## **S1603: Warlands Farm, Shalfleet; Specific Defect Survey**

Further to your recent instruction I write to confirm comments made during inspection of the Main Barn at Warlands Farm.

You have provided us a copy of MODH Design's proposals for the conversion of the Barn.

N
PROPOSED FIRST FLOOR PLAN
 1:100 @ A3 // 1:50 @ A1
 0 1 2 3 4 5 METRES

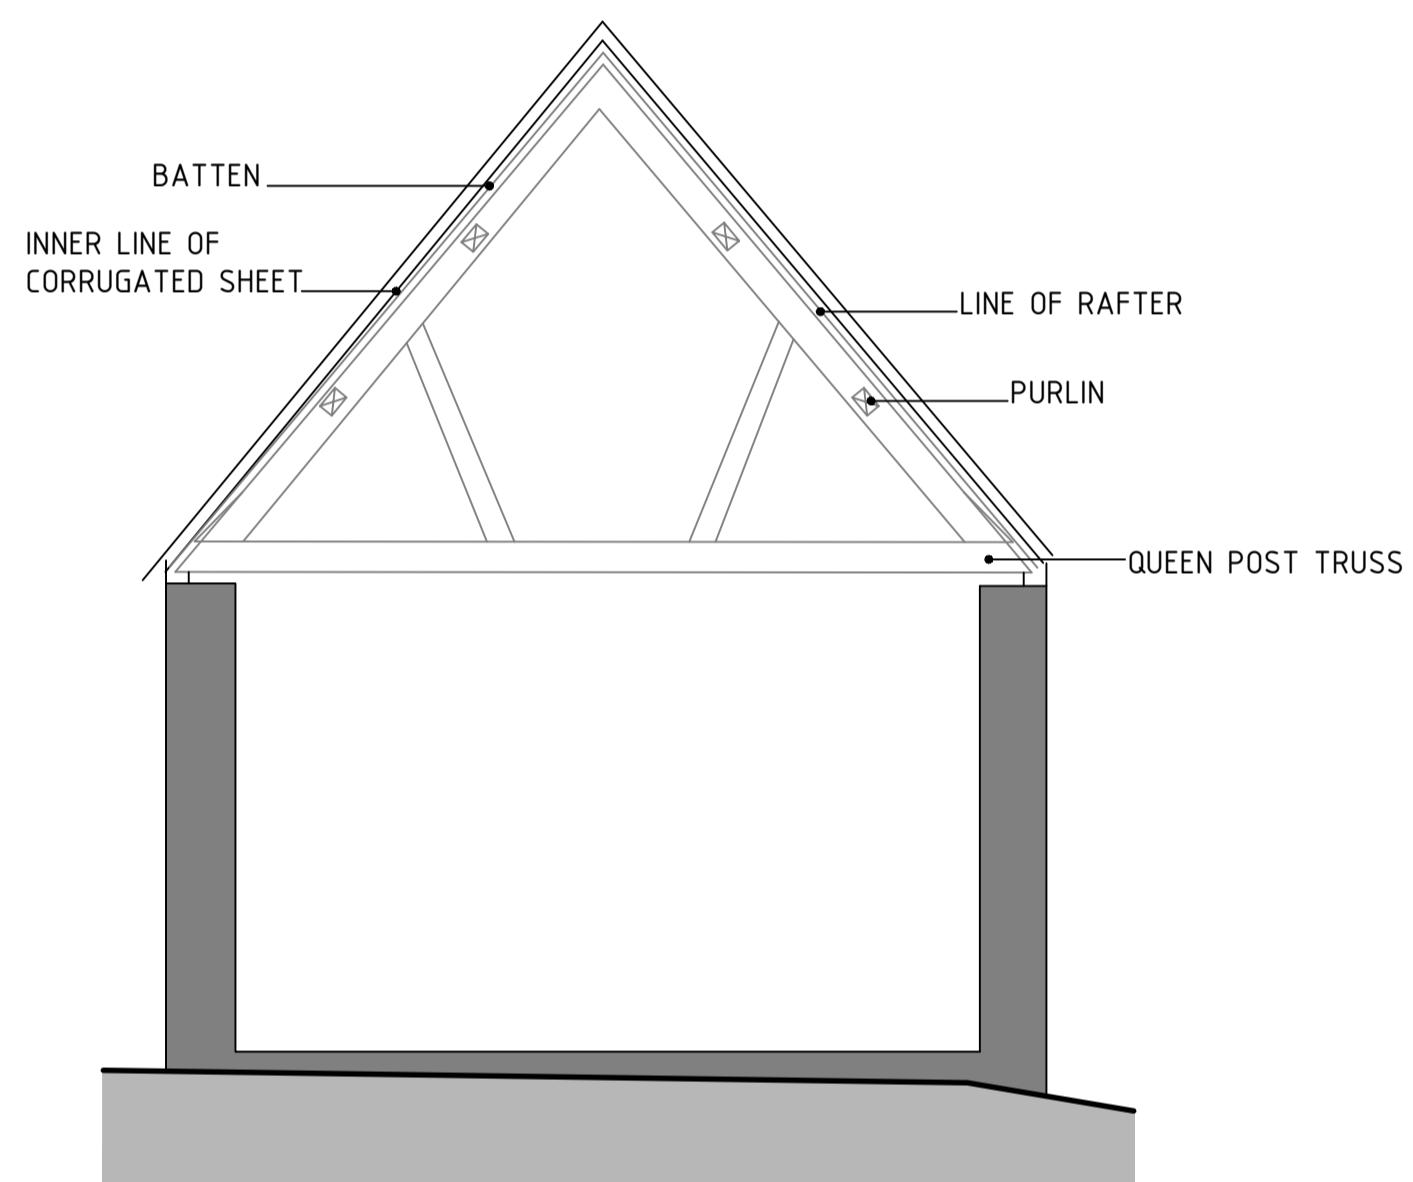
The proposals include some sub-division of the ground floor space and the addition of partial first floor rooms.

The first-floor bedrooms created within each end bay, against the gables, give an opportunity to provide enhanced lateral restraint to the existing stone walls that have been noted as out of plumb (not measured).

Independently support new first floor on, and provide lateral restraint within, inserted timber frame to the existing stone walls.

PROPOSED GENERAL SECTION
 1:100 @ A3 // 1:50 @ A1

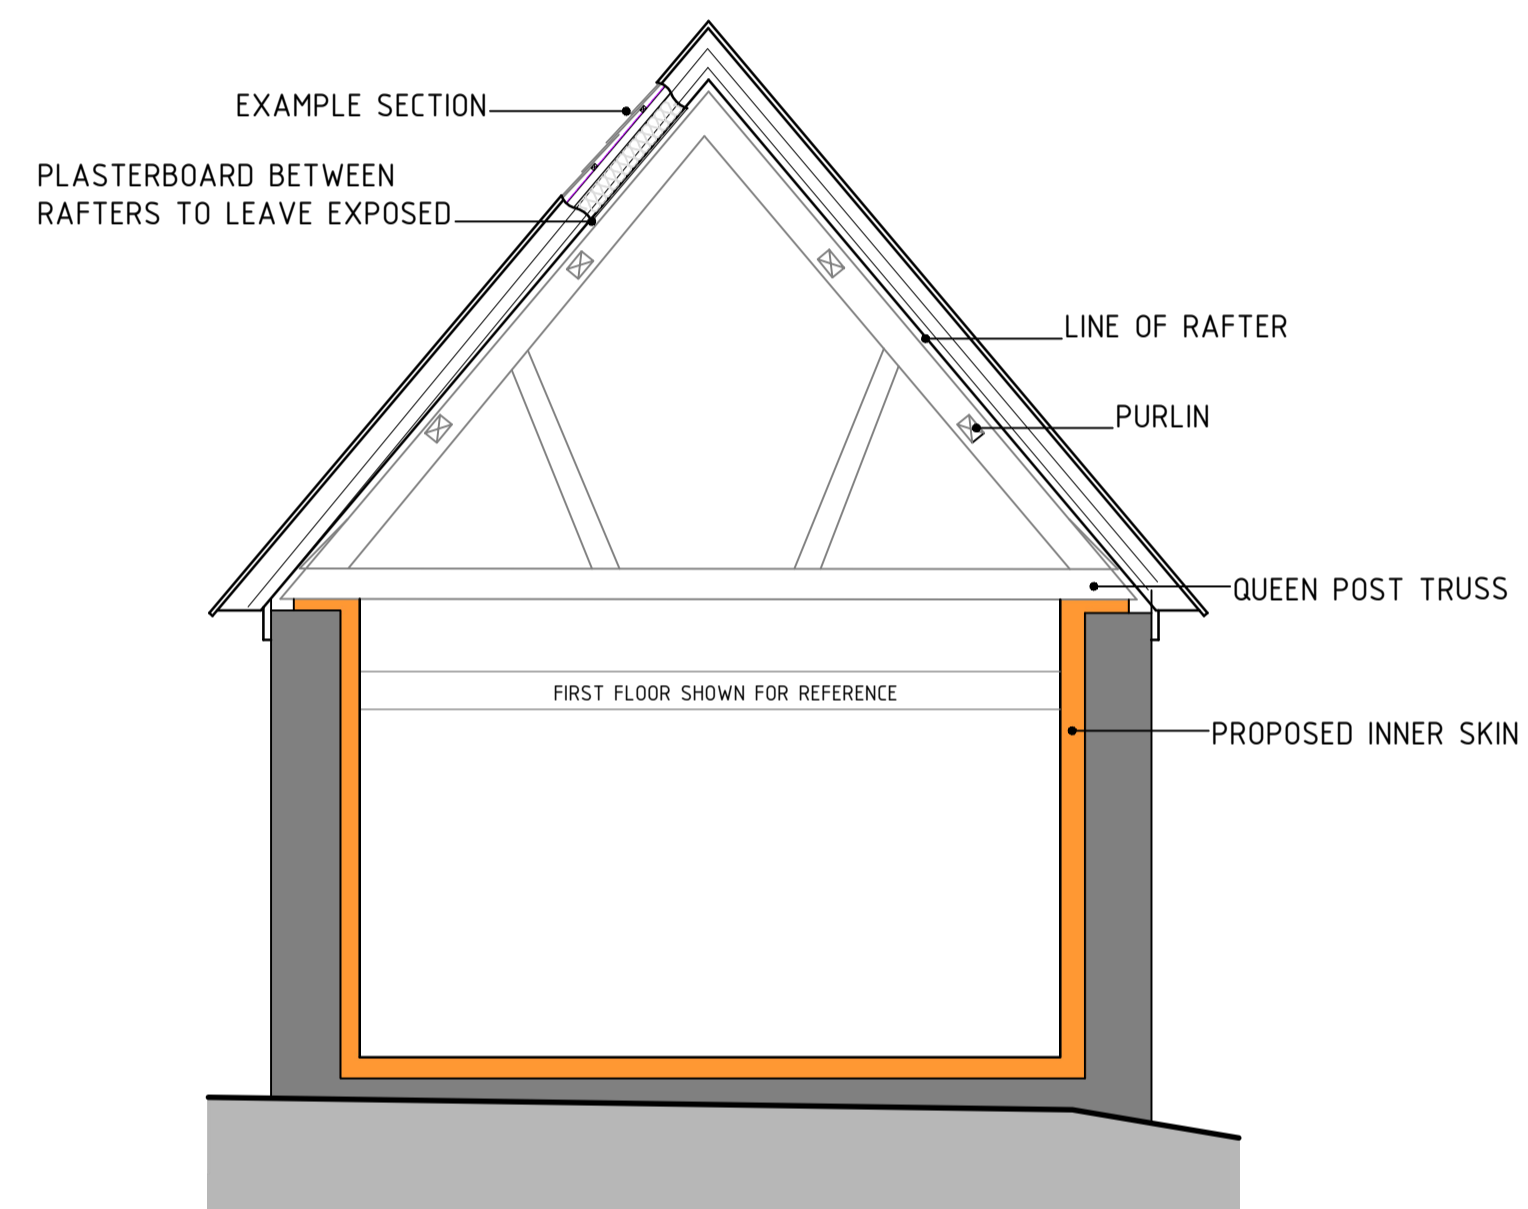
It is noted the intention is to replace the corrugated iron roof covering with slate and therefore although the cut timber roof structure will have supported a heavier roof covering in the past, design checks will be needed to the rafters, purlins, and the principal queen post trusses.

Localised strengthening of the roof structure might be necessary, and this can be combined with provision of lateral restraint to the stone walls.

The ground floor level will need to be set to avoid the floor make-up undermining the formation of the stone walls and will need to support the new timber frame to the first floors independently of the stone walls.

New floor make-up to avoid undermining existing walls with reinforced concrete slab across trench footings across the barn and with slab cantilevering against the gables.

PROPOSED SOUTH (REAR) ELEVATION

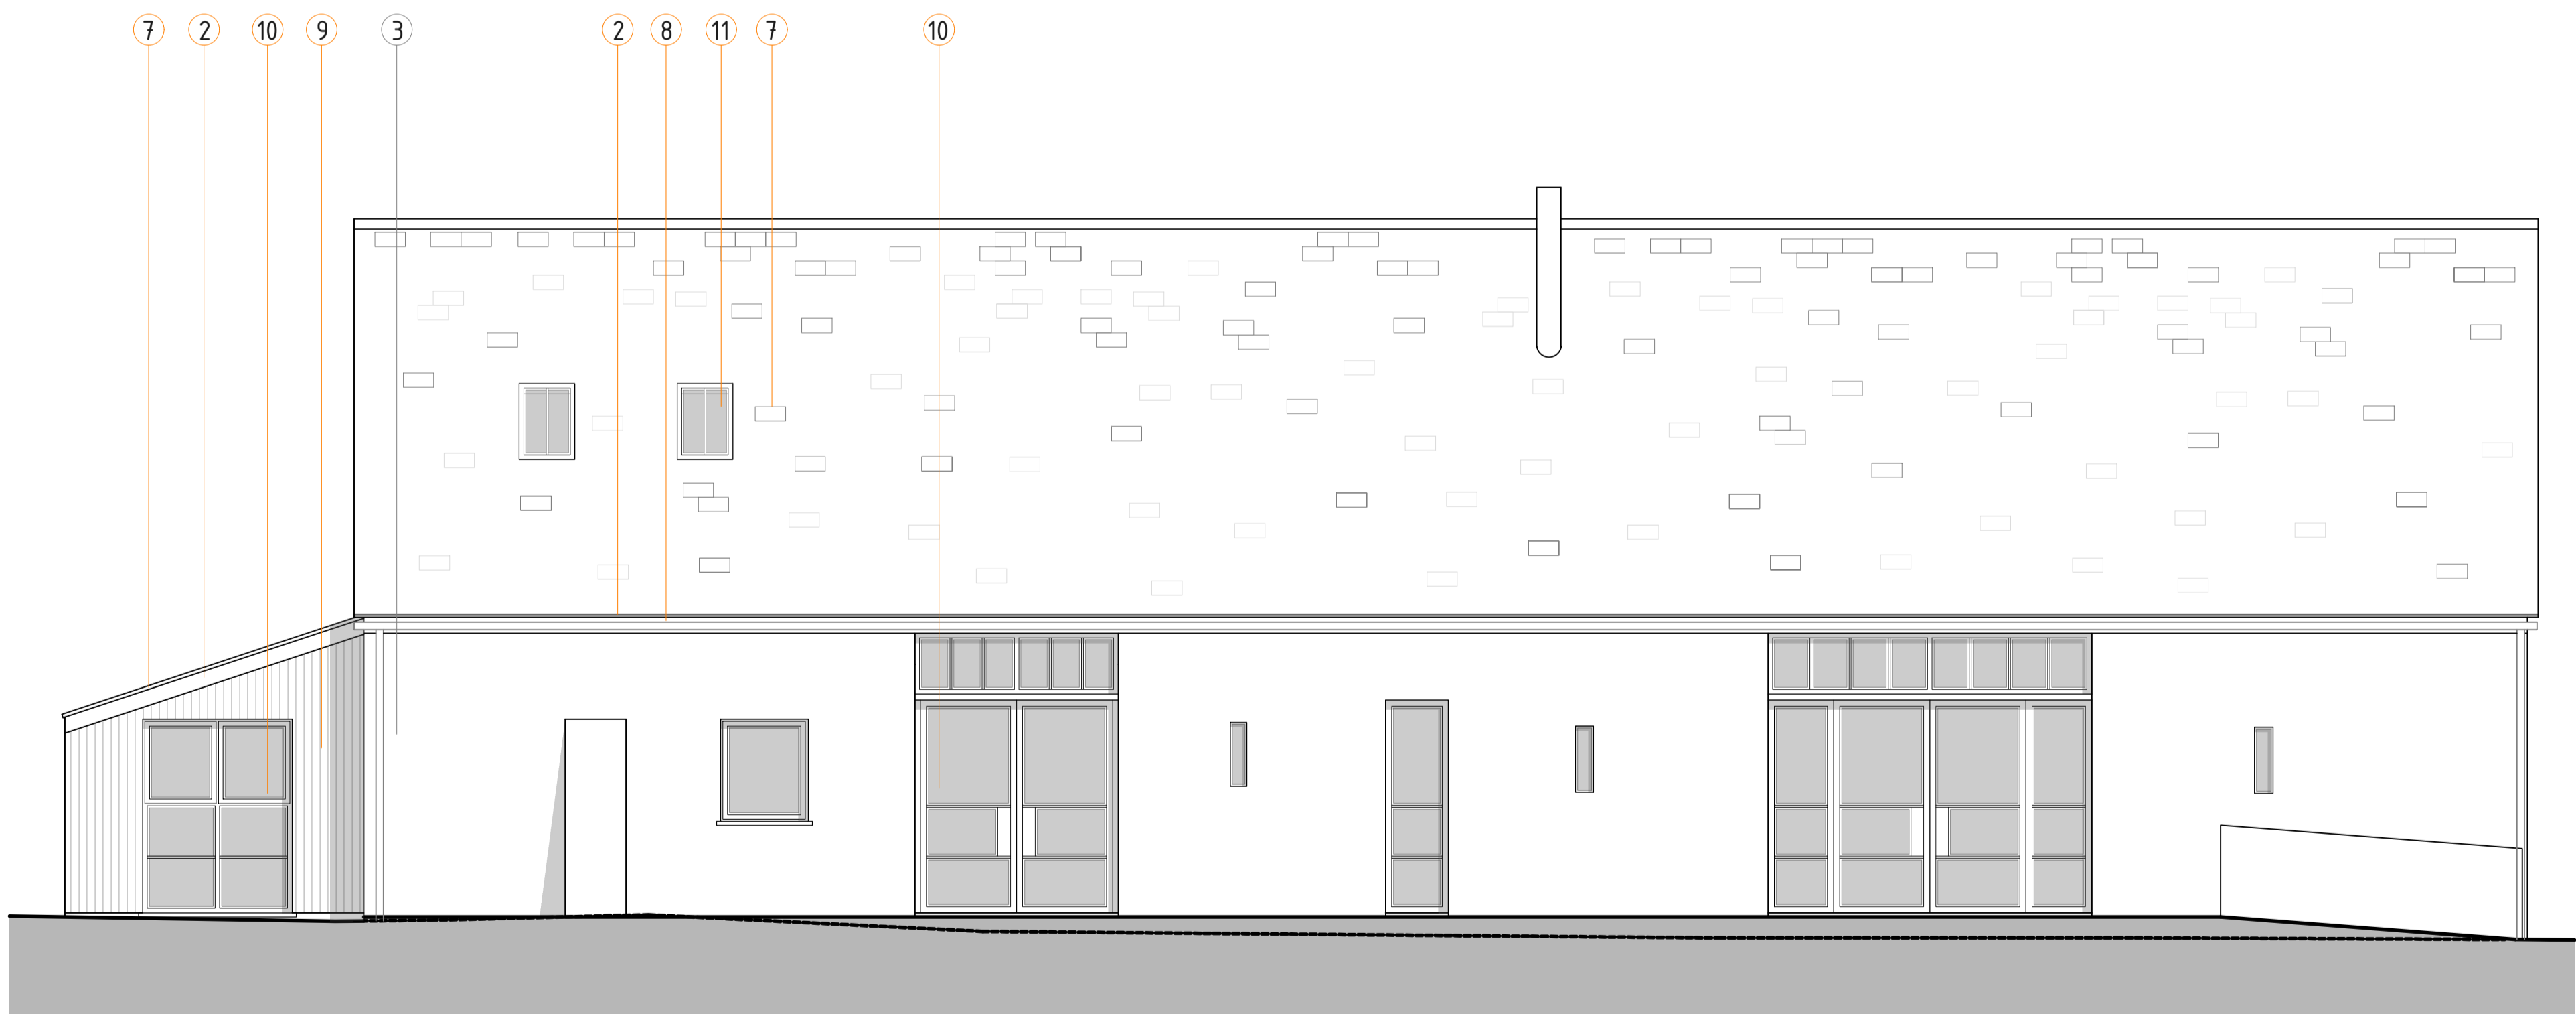
In terms of fenestration, the proposals for the most part use the existing openings or previously blocked up openings. other than extending a small central window on the southern elevation down to create a narrow slot window to ground level and adding a few small roof lights.

Localised strengthening will be necessary around the proposed slot window.
